From: Andrew Wood
Sent: 10 May 2019 13:43
To: Planning.Responses
Subject: FW: M/24/19/PL - 3 The Hard, Elmer
Attachments: 789 PL001 Proposed Floor Plans Site and Location Plans REV B.pdf; 789 PL002 Proposed Elevations and Sections REV B.pdf

I respect of the above application and in response to the comments raised by the Environment Agency in their consultation, please find attached amended drawings PL001 A and PL002 A indicating the existing raised bund running east west across the site as being retained.

PROPOSED FIRST
FLOOR PLAN
1:50

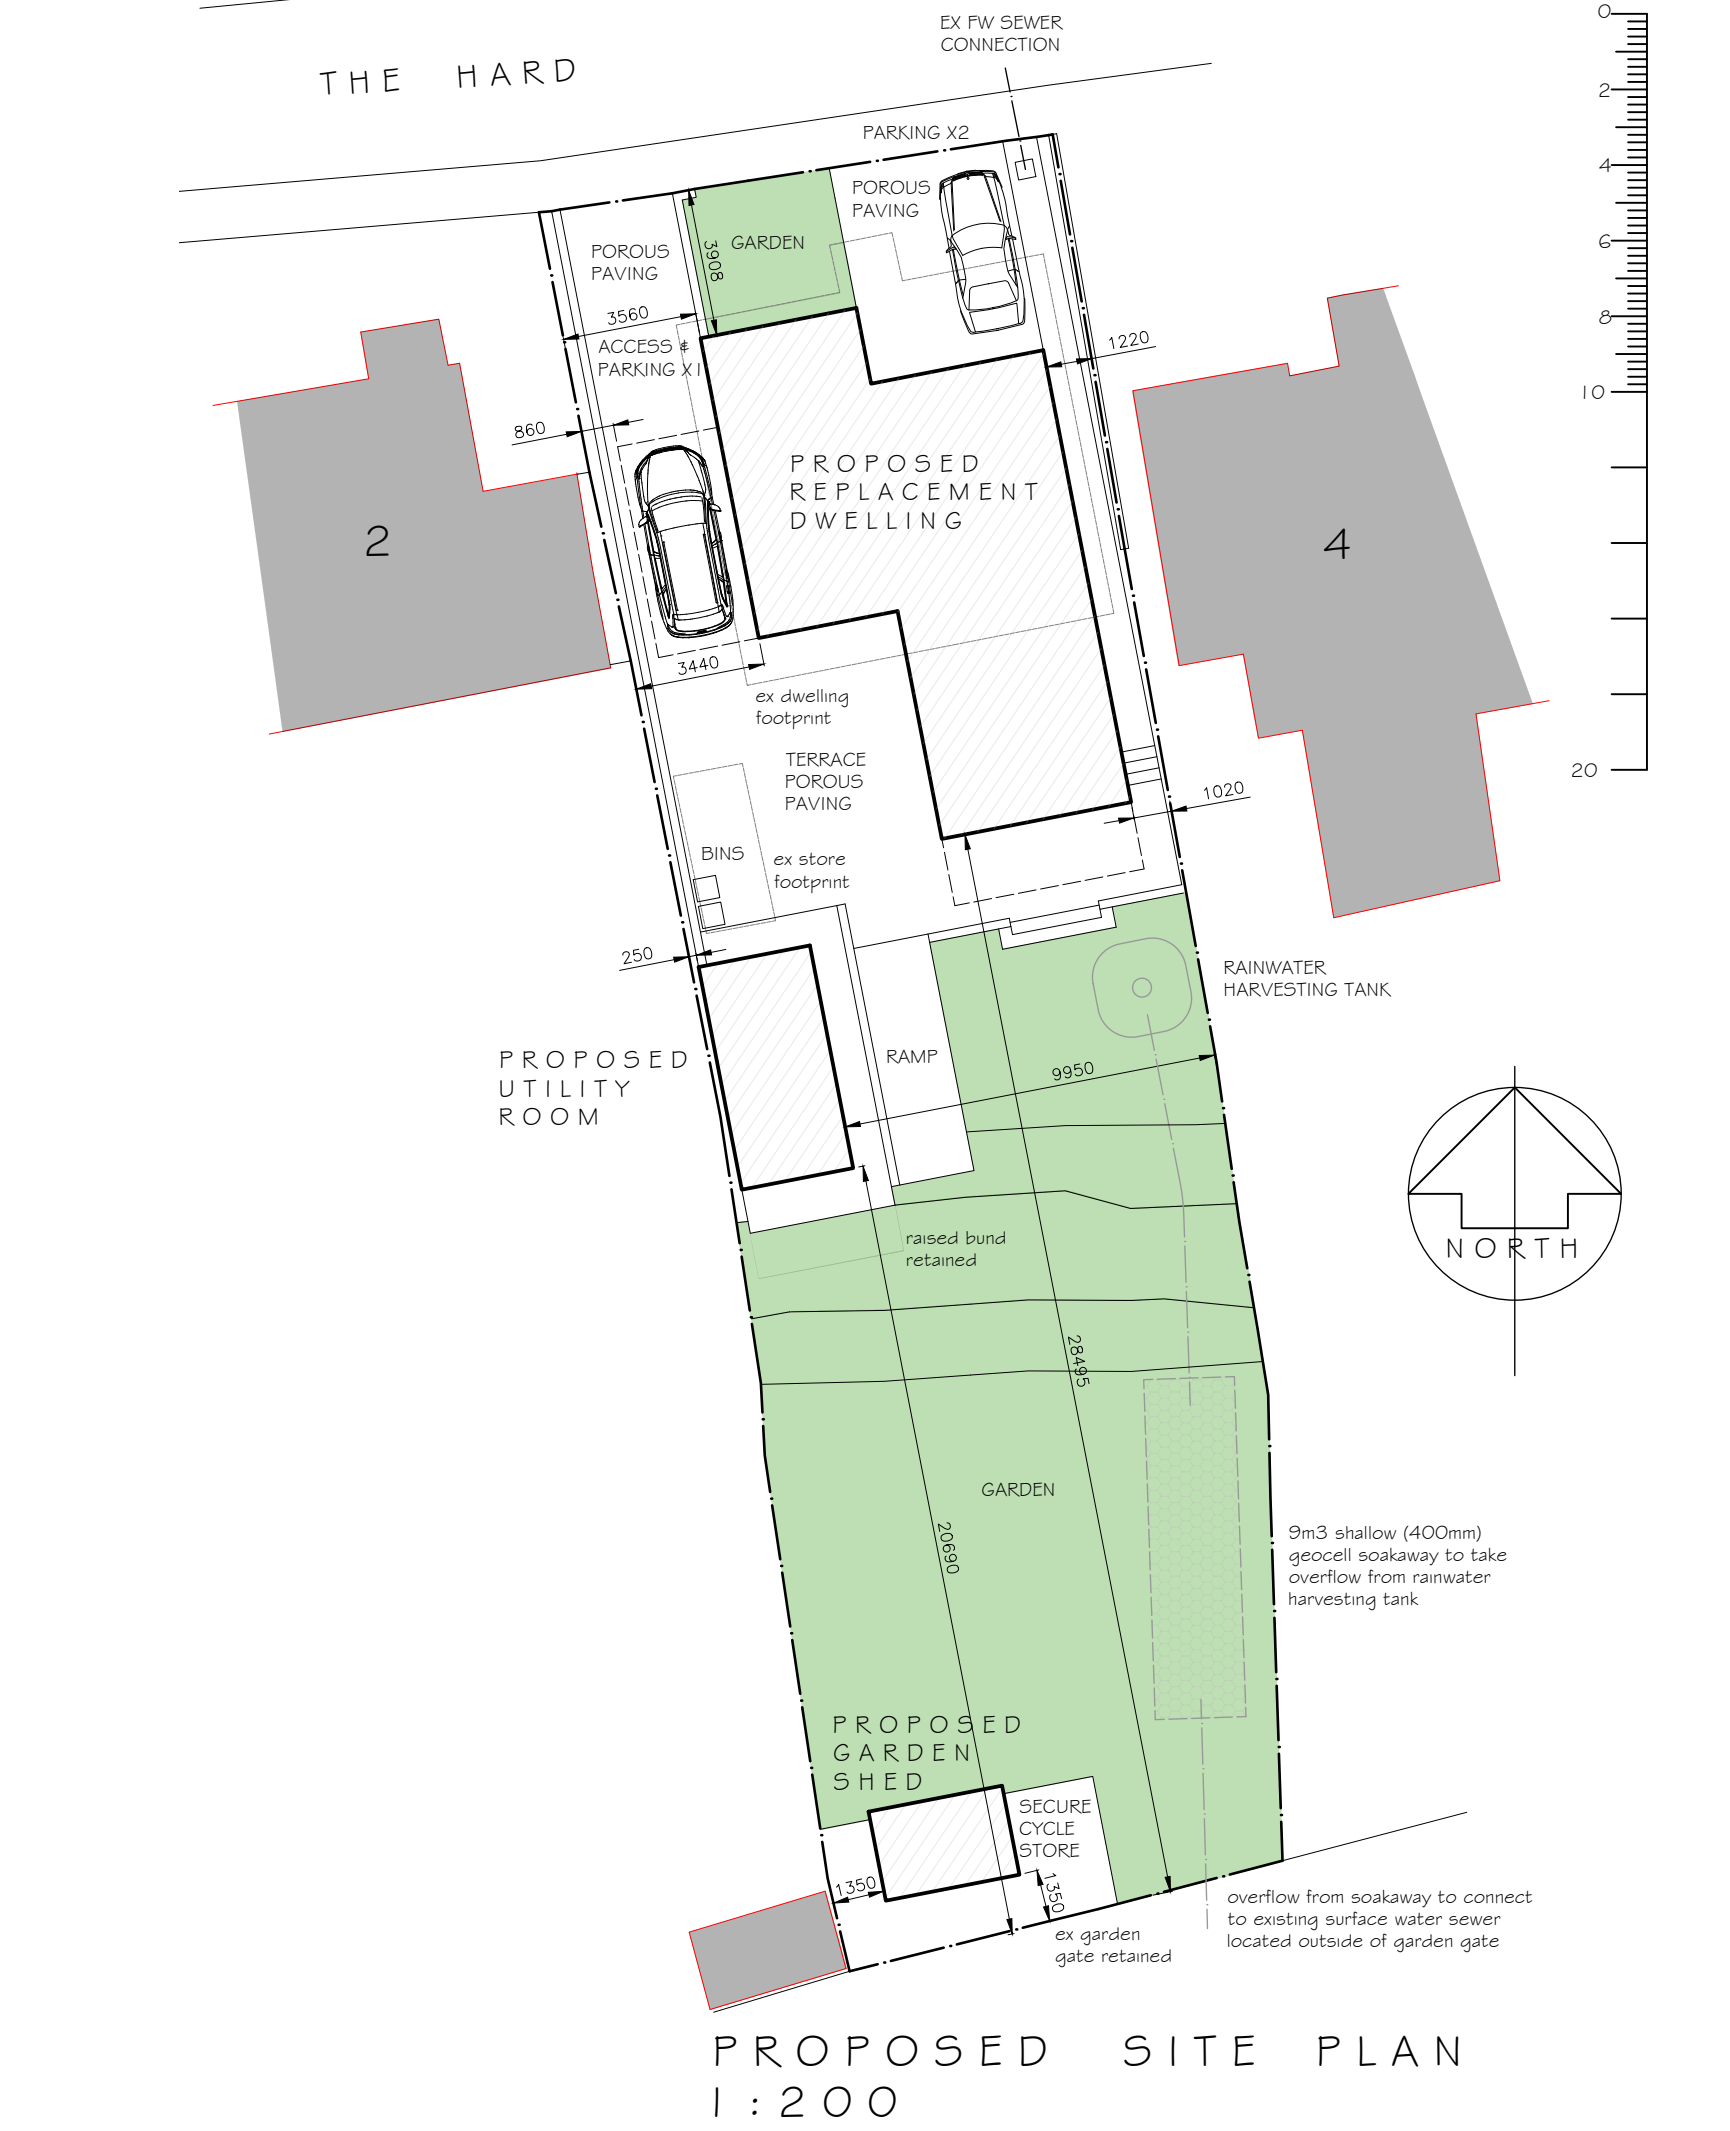
- * an obscure glazed balcony screen 1.7 metres in height on the west side of the first floor balcony serving the master bedroom.
- * Details of the two bicycle parking spaces within the rear shed mentioned in your design and access statement i.e what will they be locked to.

- * Can you please indicate that the side elevation windows will be obscure glazed and non opening below 1.7 metres in height in the case of the east elevation window at first floor level.

- * - indicate on plan and elevation where wheely bin and recycling storage cupboards will be.
- * Details of the proposed lighting scheme in accordance with the ecologist comments relating to biodiversity 'avoiding unnecessary artificial light spill through the use of directional light sources and shielding.'

1. The west elevation of the balcony to the master bedroom will be fitted with a minimum 1.7m high tapered screen comprising frosted glass to provide privacy.

6. The side window serving the master bedroom en suite will be obscure glazed at all times and be non opening.
7. The wheelie bins for general waste and recycling will be located in a stand alone timber clad 'cupboard', in the location originally indicated on the 1:200 site plan and now indicated on the 1:50 floor plan and 1:100 elevations. The timber will be western red cedar to match.
